## M54 to M6 Link Project

Examining Authority's Consultation Draft Development Consent Order.

Schedule of Recommended Amendments to the Applicant's draft Development Consent Order (DCO) submitted at Deadline 6 [REP6-002/REP6-003]

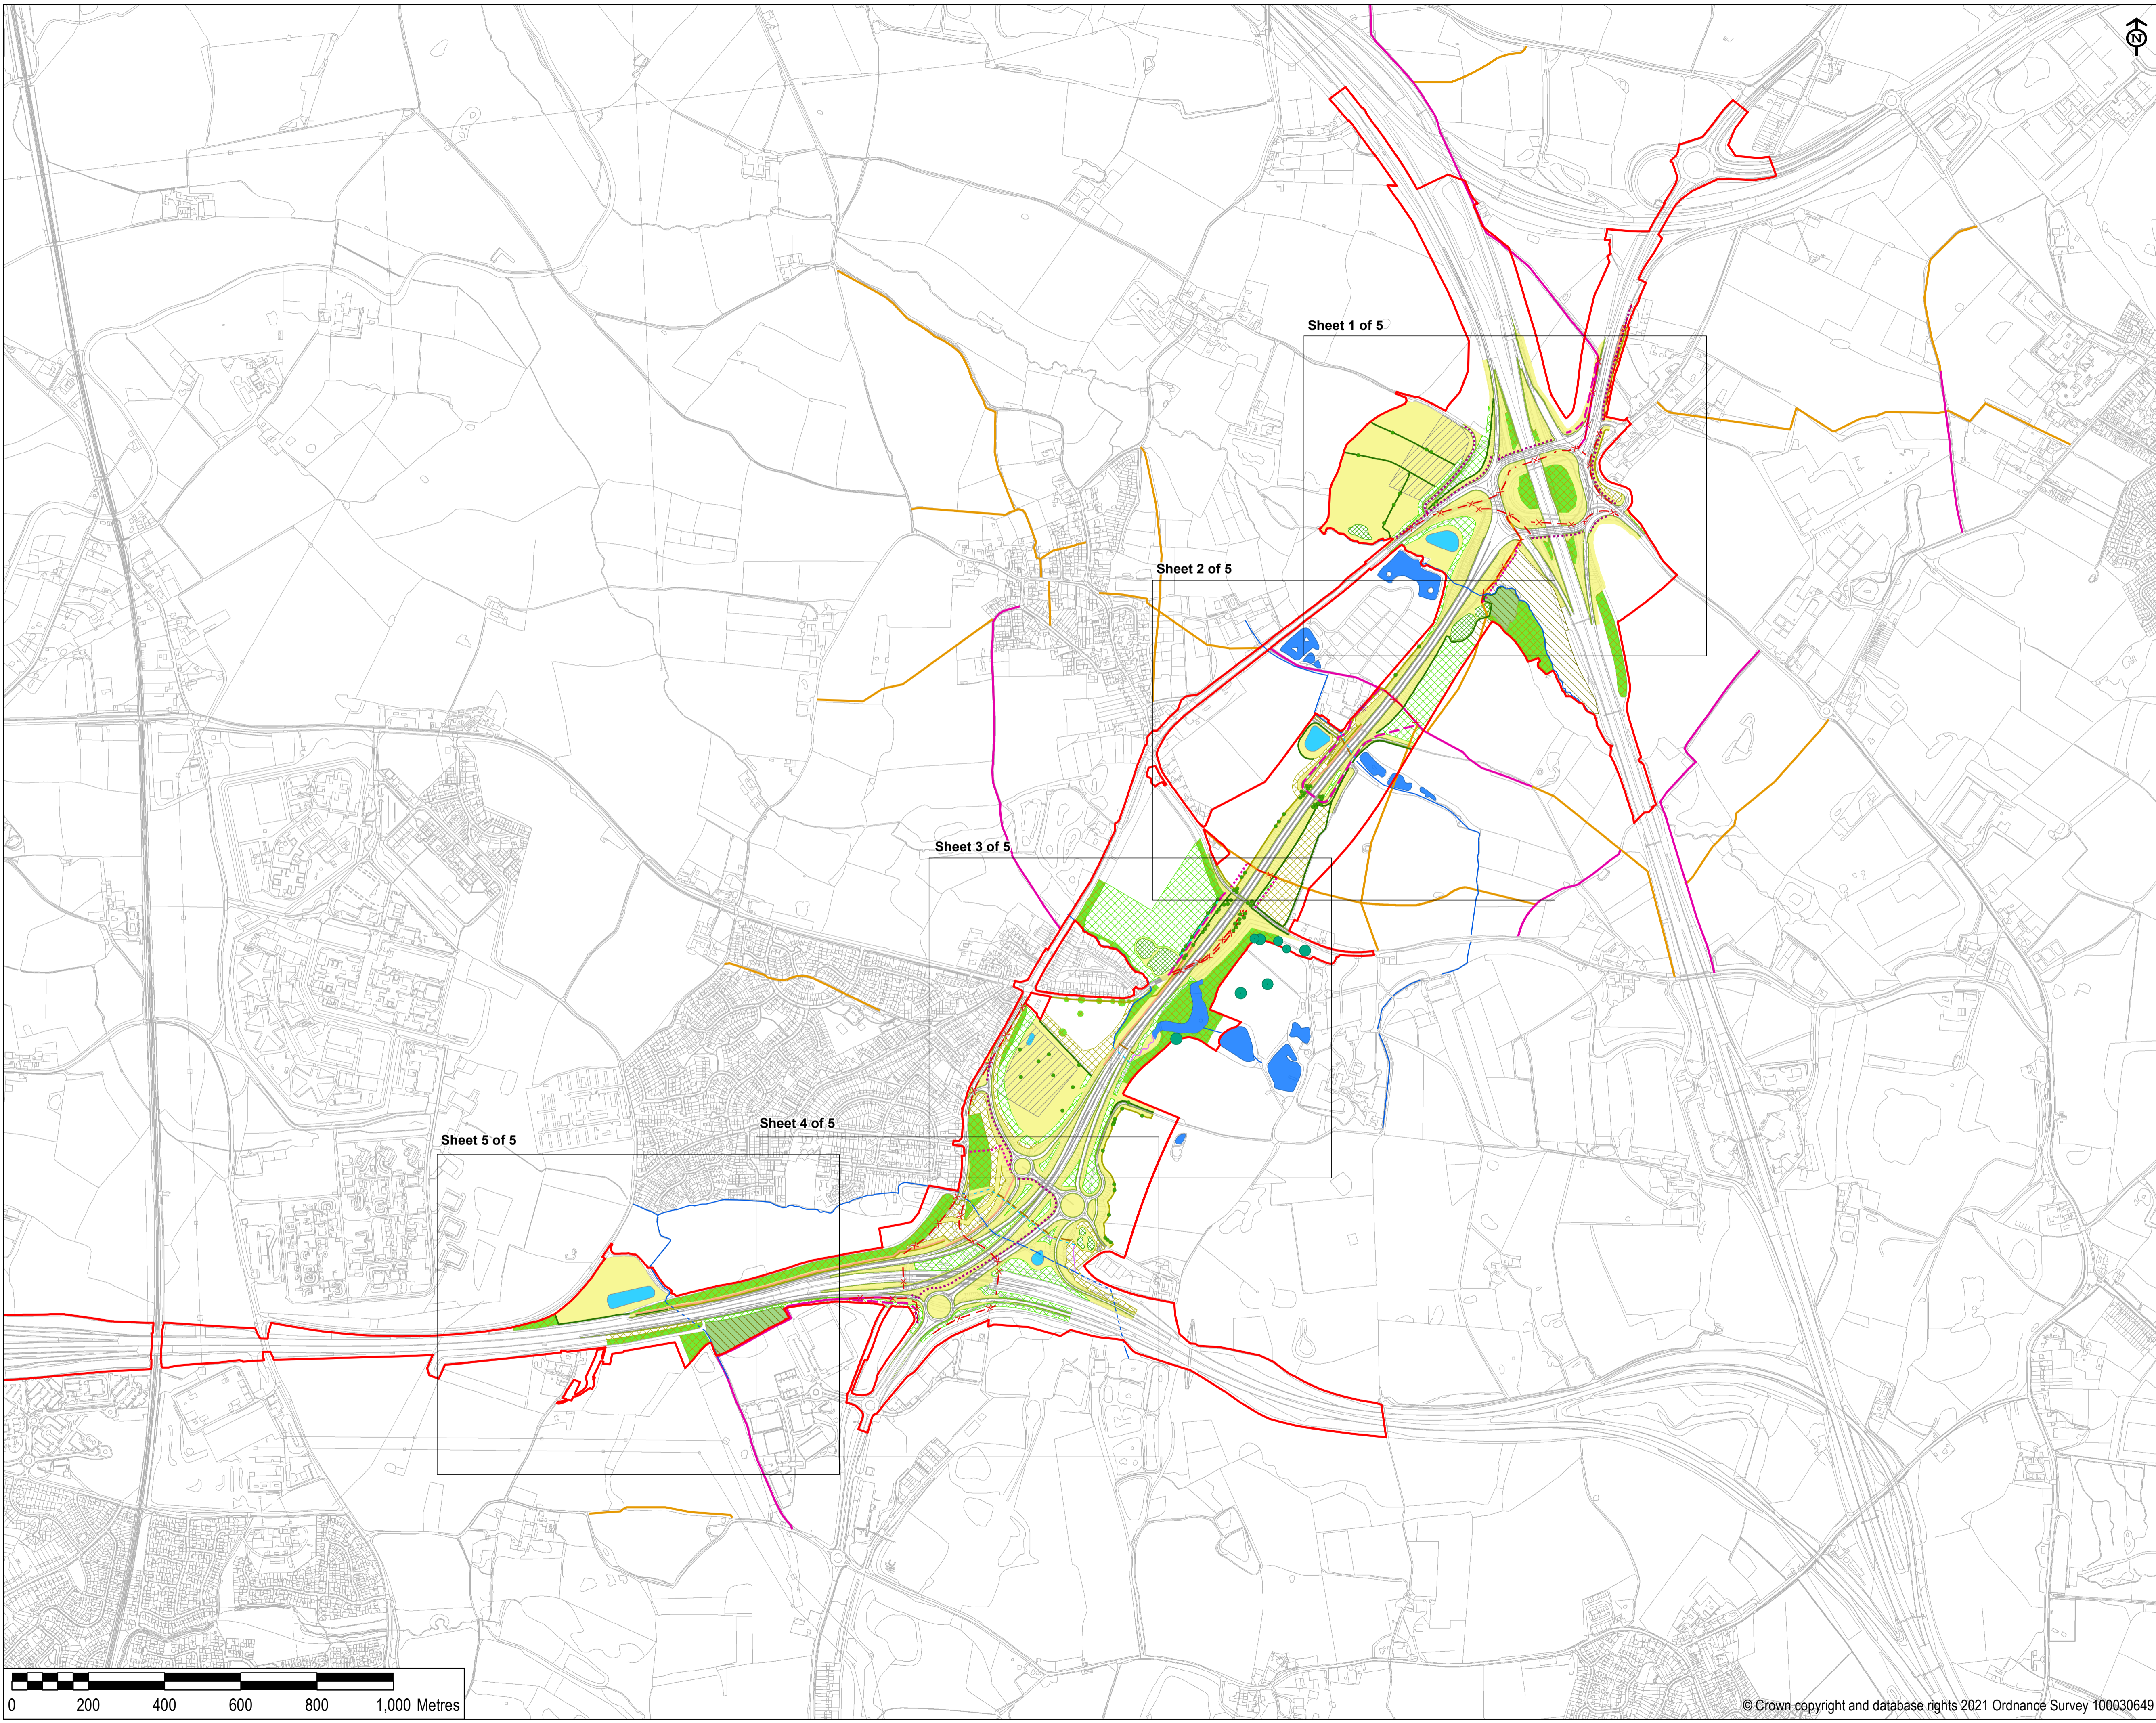
1. Could the Applicant please ensure that the agreed fence to be installed along the southern side of Dark Lane is identified, either as a Work in Schedule 1, or within the Environmental Masterplan (master and sheet 3), and any other necessary document amended.
2. Could the Applicant please ensure that Article 8(4) covers all the necessary statutory undertakers so as to be in accordance with the final Protective Provisions to be set out in Schedule 9.
3. In addition, there a significant number (34) of occasions in the draft DCO where there is a double space. These should be checked and generally replaced with a single space.
